Rezoning Transportation Analysis

Petition Number: 2023-040

Date	Description
7-27-23	First Review (PDM)
03-20-24	Second Review (KC)

SHEET NUMBER  
**RZ-01**

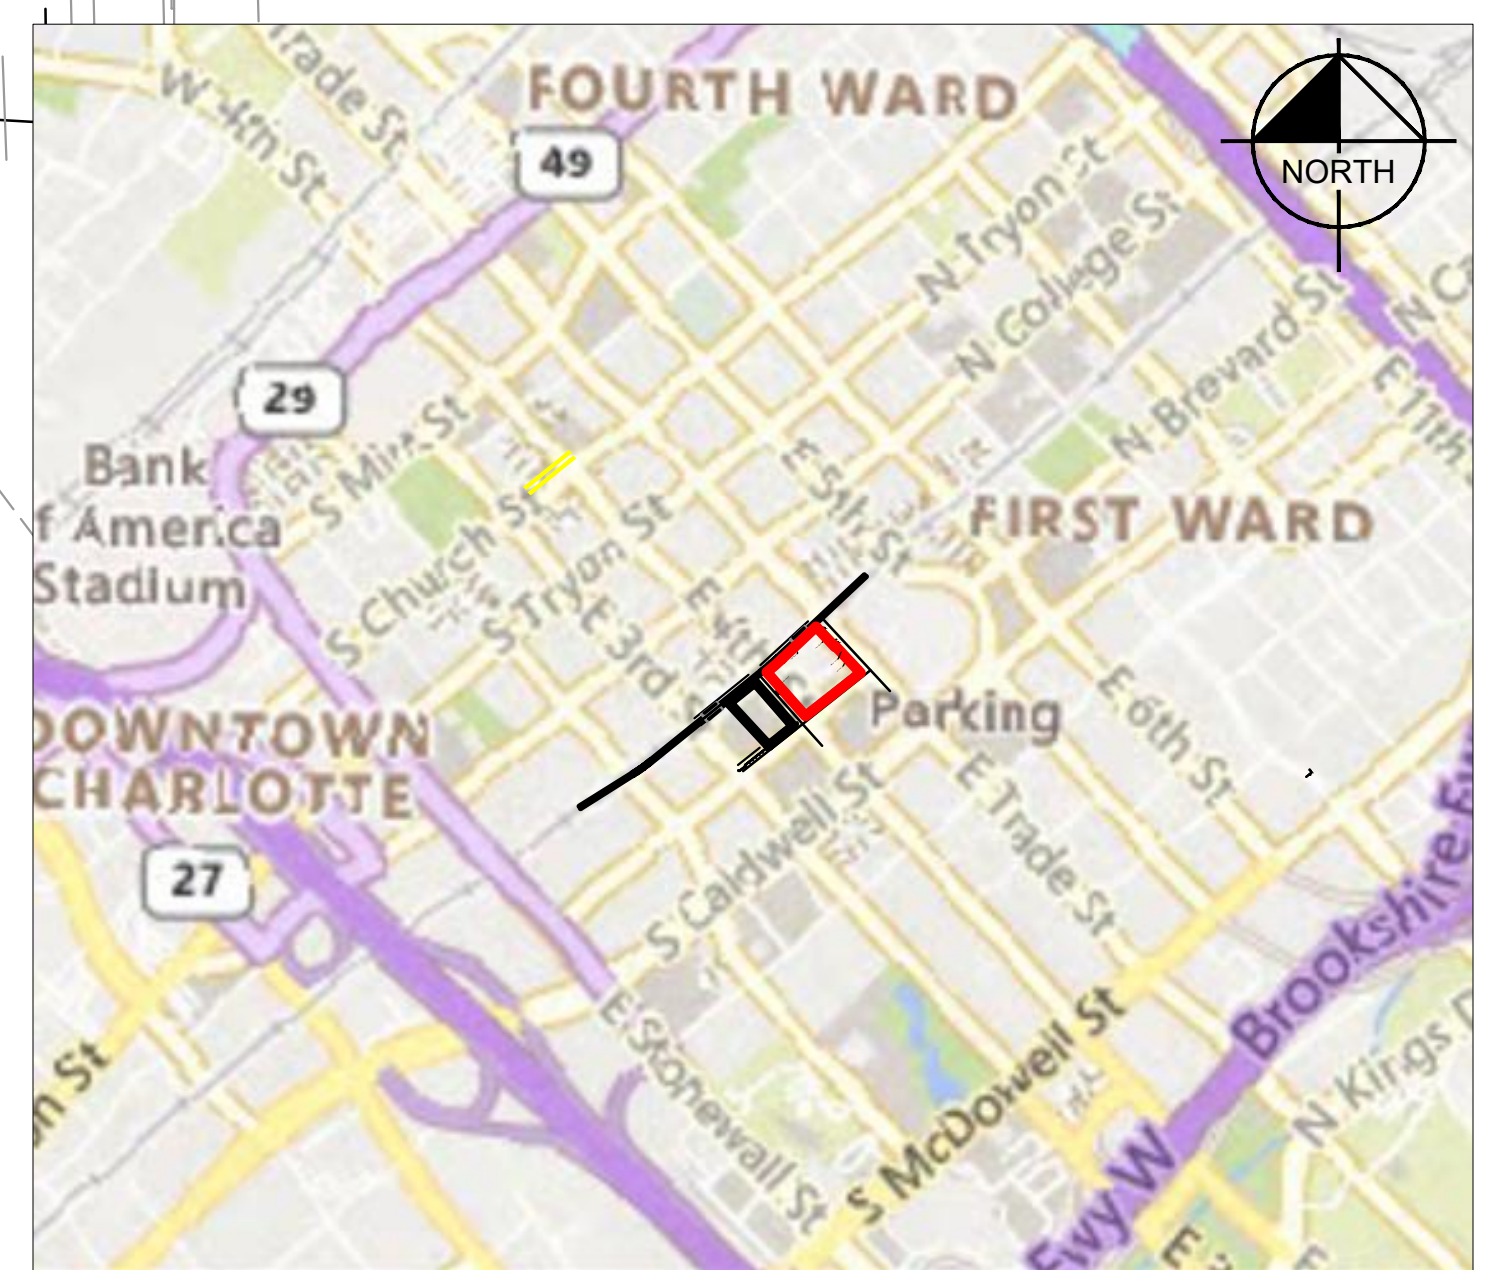
- Outstanding Comment 03-20-24:** Revise site plan and conditional note(s) to commit to construct bicycle facilities by installing a multi-use path on Trade Street, Brevard Street, and 4th Street to meet the Council-adopted Charlotte BIKES Policy. Multi-use paths maintained by the City shall meet ADA/PROWAG requirements.

Clarifying Comment 03-20-24: Update site plan and conditional note(s) to commit to construct bicycle facilities by installing a multi-use path on Trade Street, Brevard Street, and 4th Street to meet the Council-adopted Charlotte BIKES Policy. Multi-use paths maintained by the City shall meet ADA/PROWAG requirements. Add dimensions to the plan for the amenity zone and paths/sidewalks for each street frontage.

- Outstanding Comment 03-20-24:** Revise site plan and conditional note(s) to commit to provide the streetscape for Uptown Signature Streets on Trade Street and Brevard Street and the streetscape for Uptown Primary Streets on 4th Street.

Clarifying Comment 03-20-24: Update site plan and conditional note(s) to commit to provide the streetscape for Uptown Signature Streets on Trade Street and Brevard Street and the streetscape for Uptown Primary Streets on 4th Street.

- Outstanding Comment 03-20-24:** Revise site plan and conditional notes to provide a 12ft rail trail along the Blue Line and provide a connection to the Rail Trail to the site that accounts for bicycle traffic within the design.

Clarifying Comment 03-20-24: Update and revise site plan to accommodate for the rail trail as shown below:
